Project #: 1009245 Application #: 12DRB-70221
Project Name: North Albuquerque Acres Unit 3
Agent: Rick Bennett Architects Phone #:

**City of Albuquerque
Planning Department
Inter-Office Memorandum**

DEVELOPMENT REVIEW BOARD – SPEED MEMO

DRB CASE NO: 1009245

6 SECTION @ RETAINING WALL  
C1 1" = 20'-0"

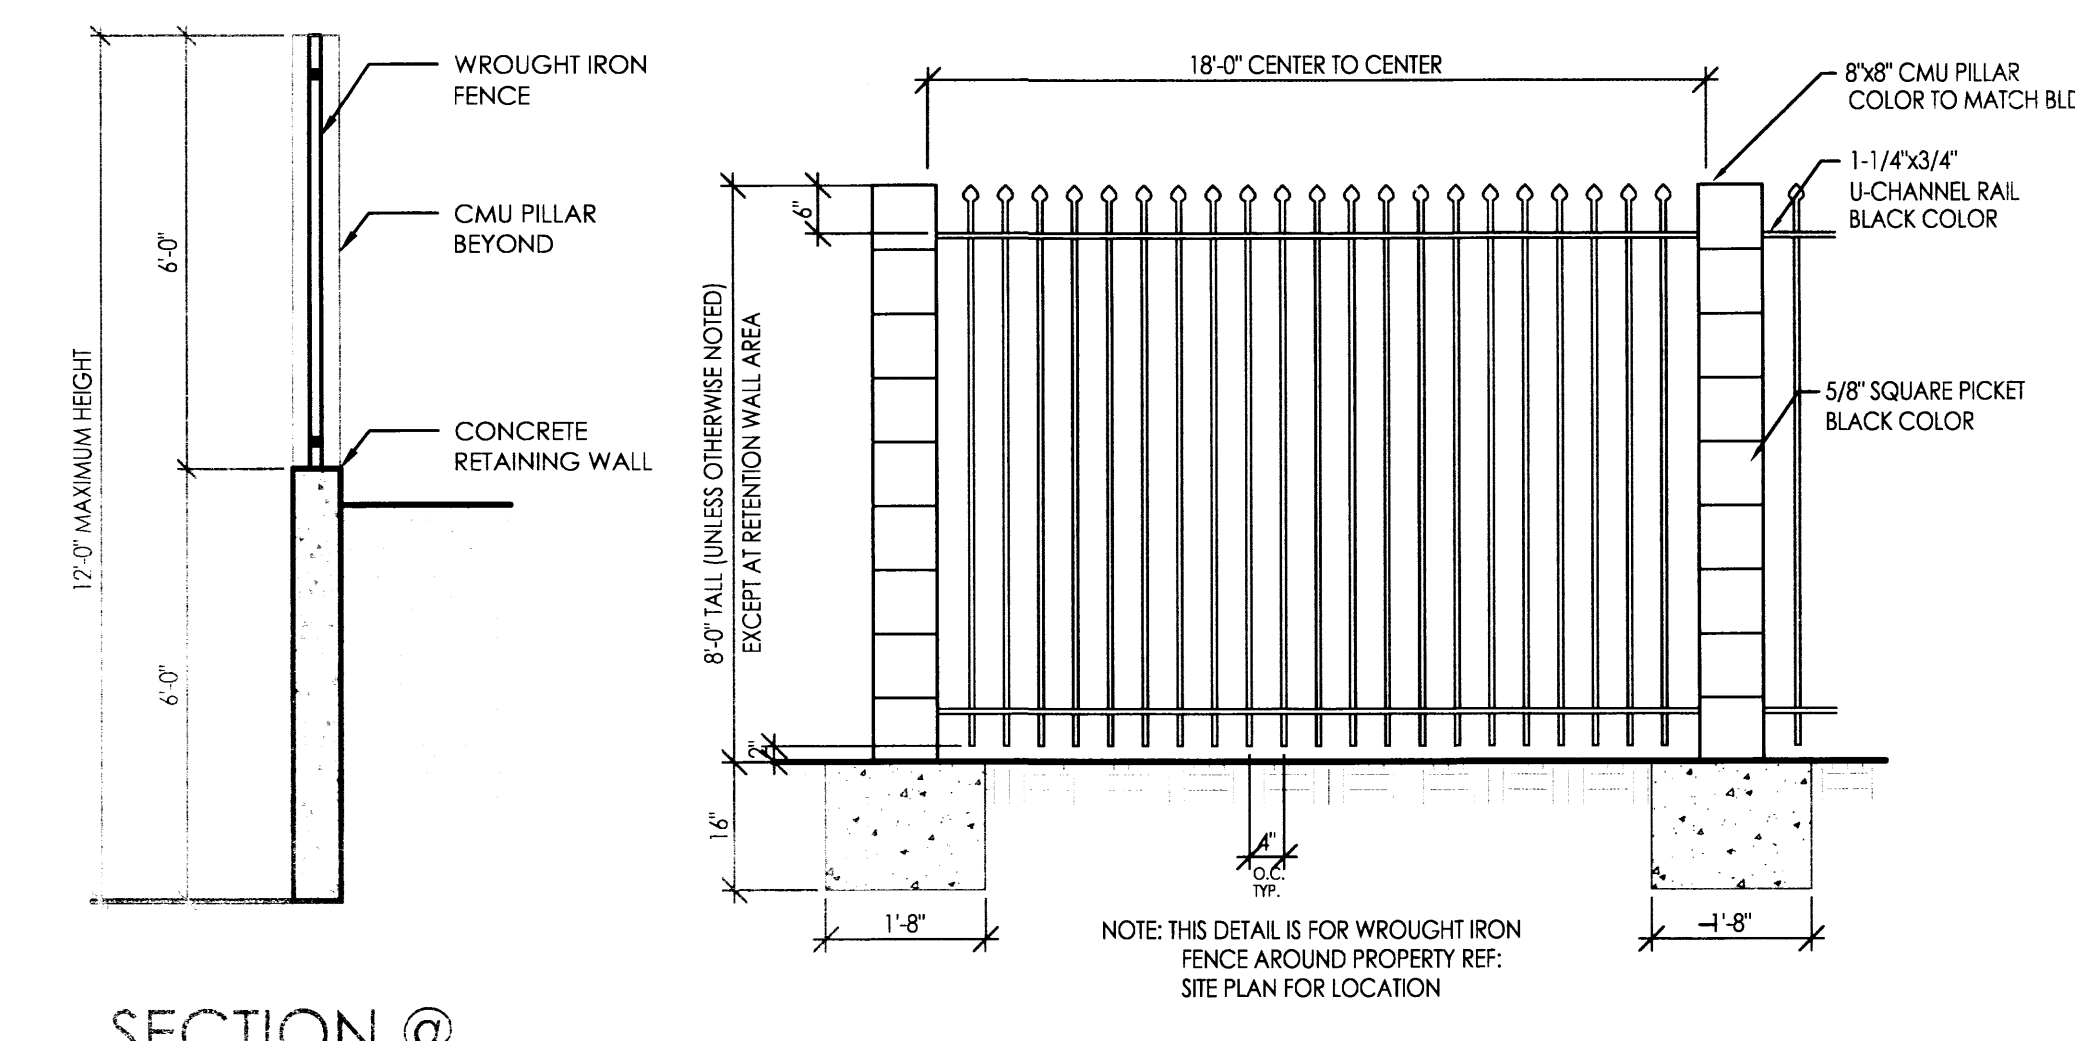
EPC Item B – A detail of the retaining wall in the north and west sides of the property has been added to the site plan.

EPC Item C – Retaining wall detail shows that the maximum height of the fence along the north and west sides of the property is not to exceed 12'-0" high, this included both the retaining wall and tubular steel fencing above it.

6 TYPICAL PERIMETER FENCE DETAIL  
C1 3/4" = 1'-0"

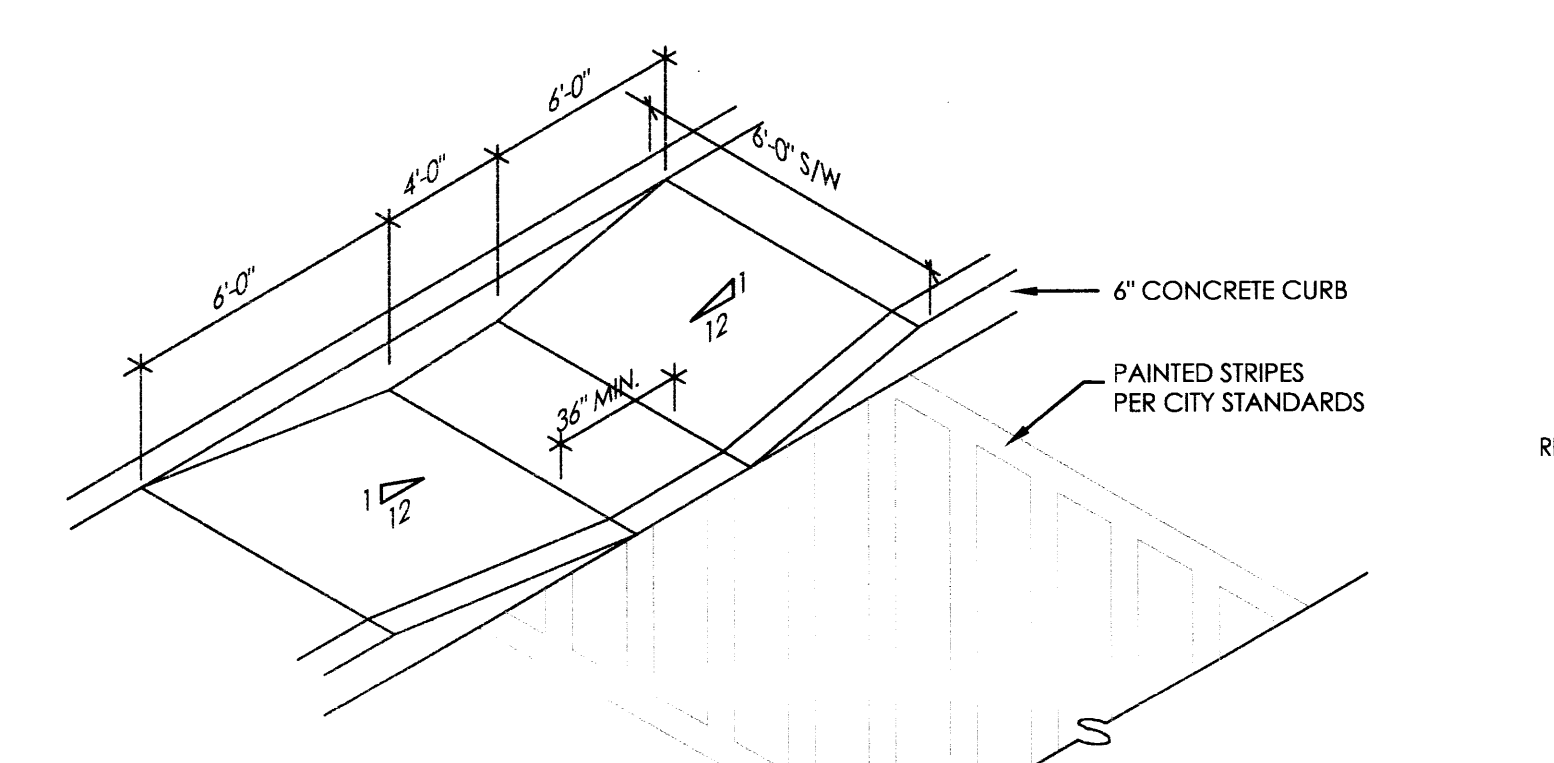
EPC Item A - 8"x8" CMU Pillars have been added to the security fencing around the perimeter of the building in order to break up the expanse of unarticulated fence.

PROPOSED SITE PLAN  
1" = 20'-0"

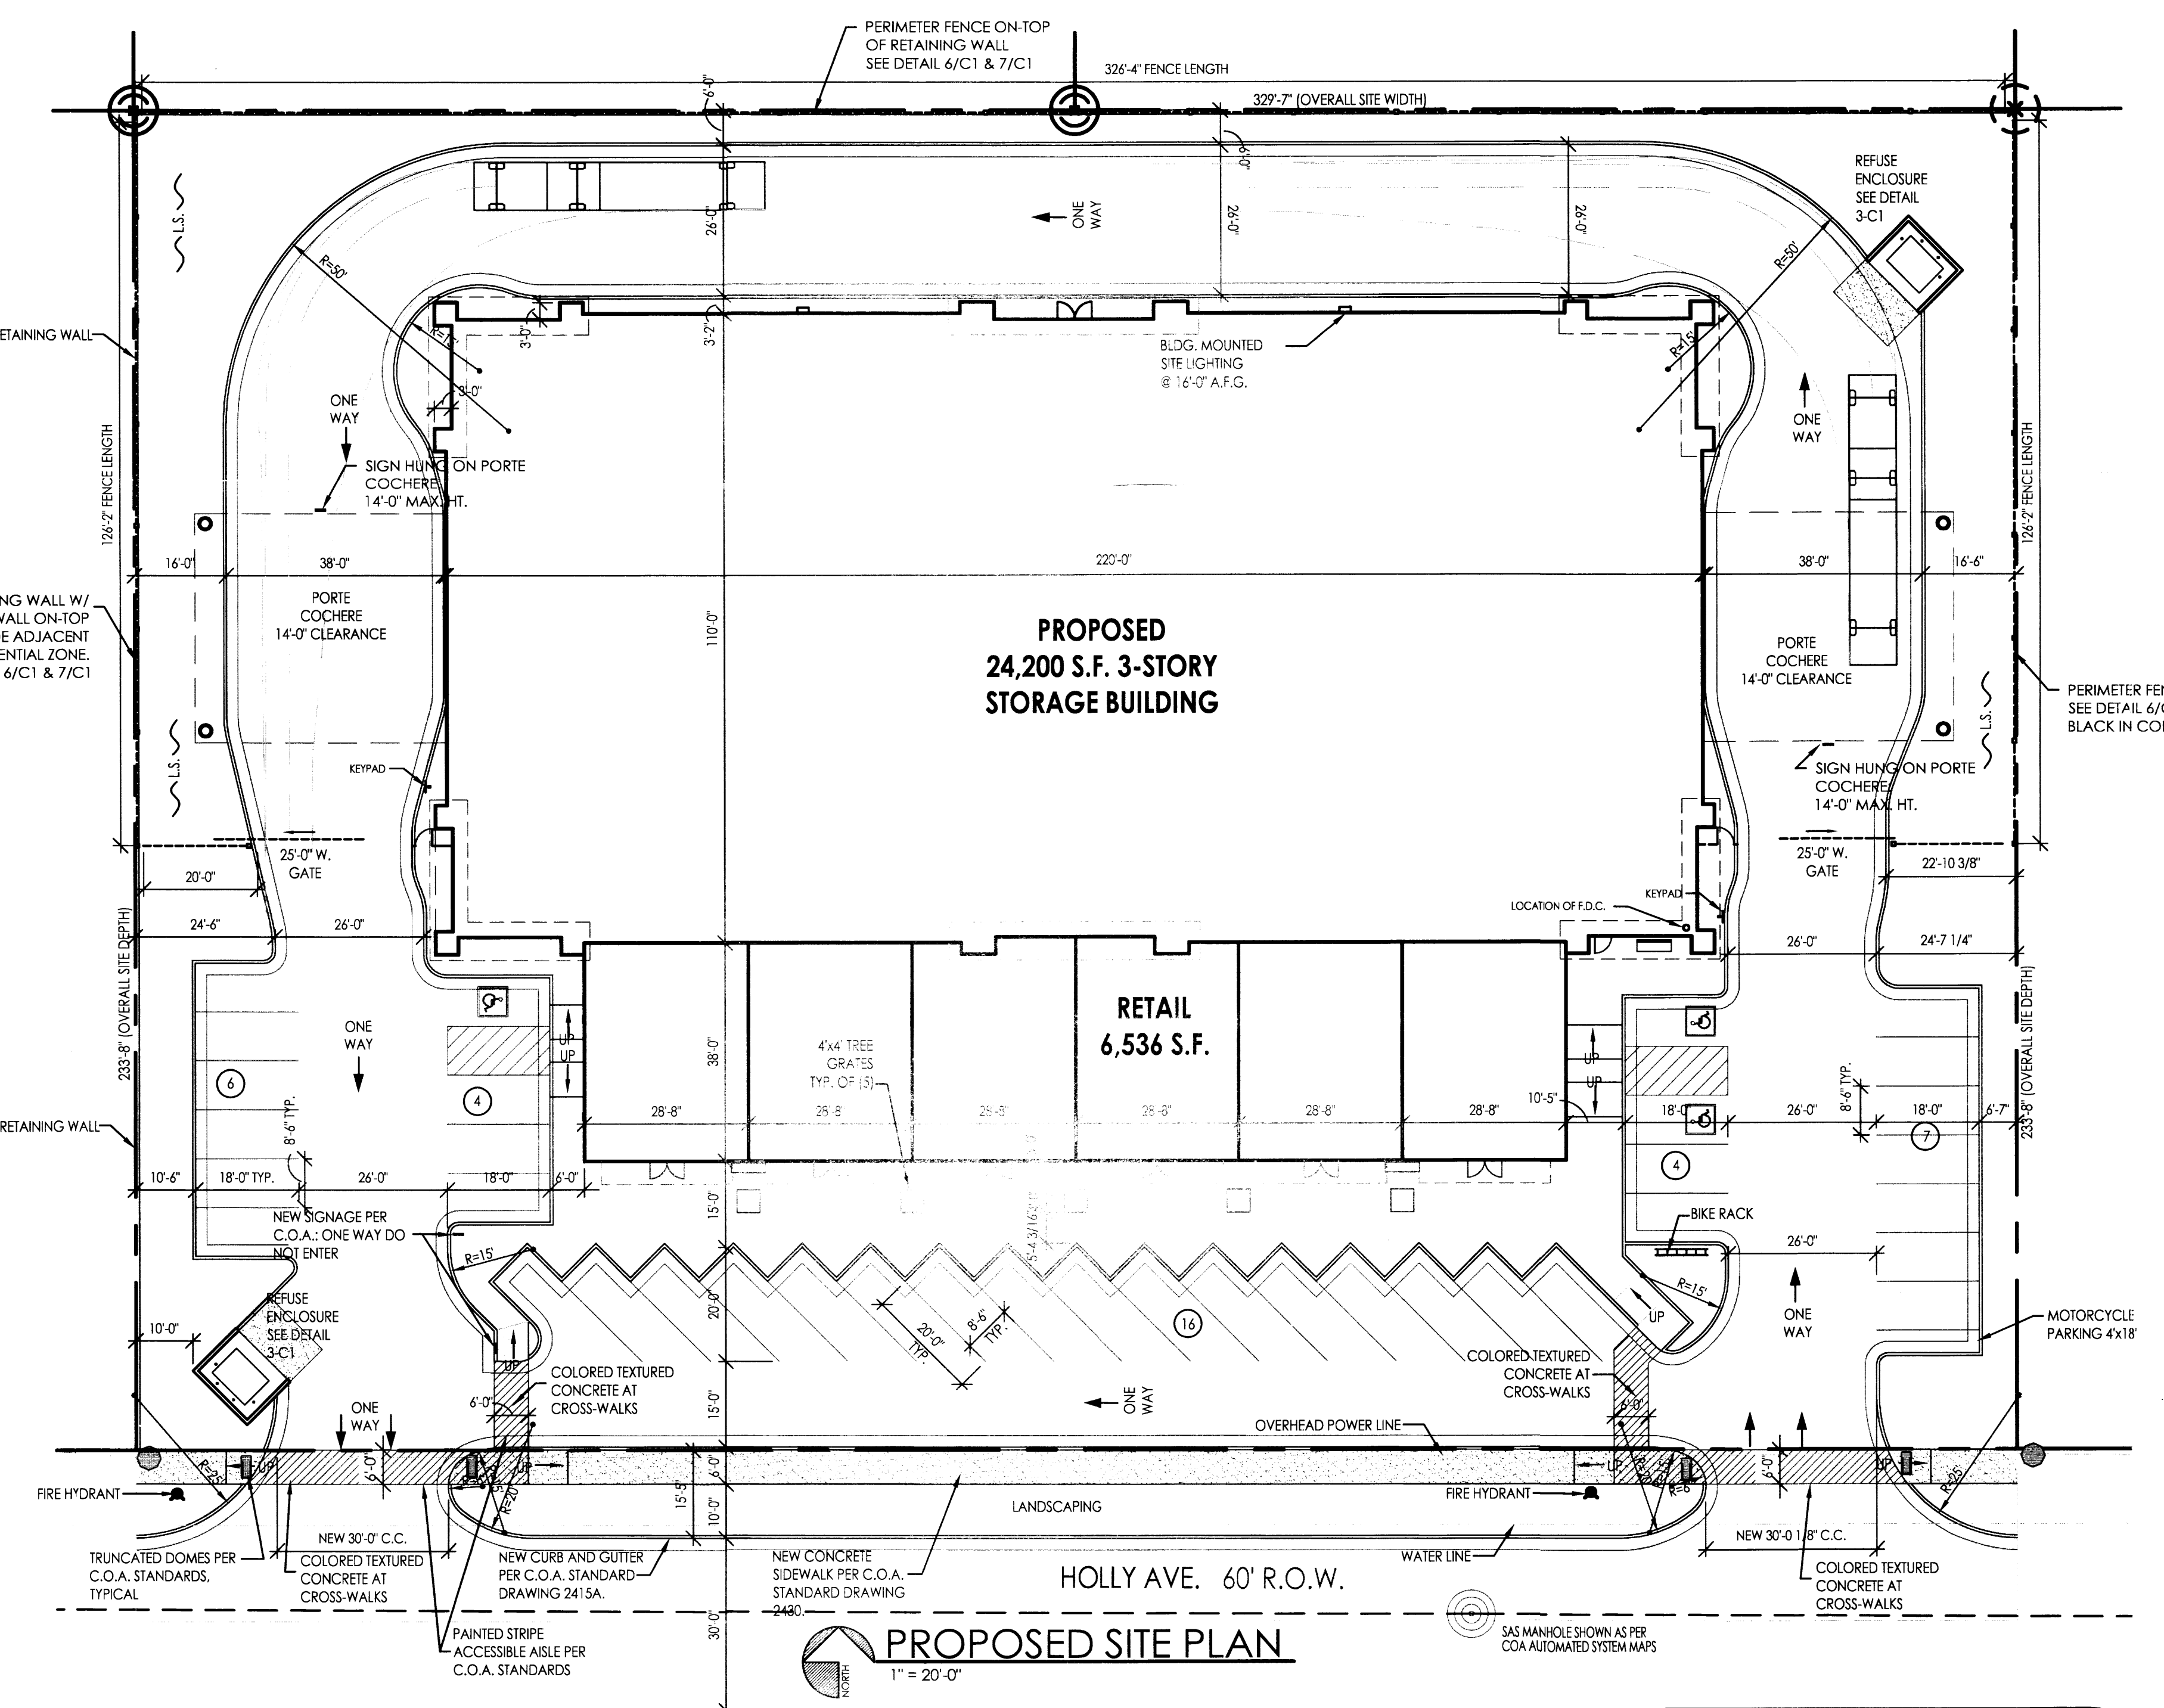
Pavement markings and signage must be provided at the exits of one-way drive aisles through out proposed development. (EPC Condition 6d)

Identify turning template information of delivery vehicle classification and size of the delivery vehicle, and provide route path from Paseo Del Norte roadway system. (EPC Condition 6e)

Identify turning template information of delivery vehicle classification and size of the delivery vehicle, and provide route path from Paseo Del Norte roadway system. (EPC Condition 6e)

D. Pavement markings and signage are shown on the site plan.

E. Turning radii have been verified with waste management and largest size truck radius has been shown on site plan. Route Path from Paseo Del Norte is access from either Louisiana Blvd. or Wyoming Blvd.
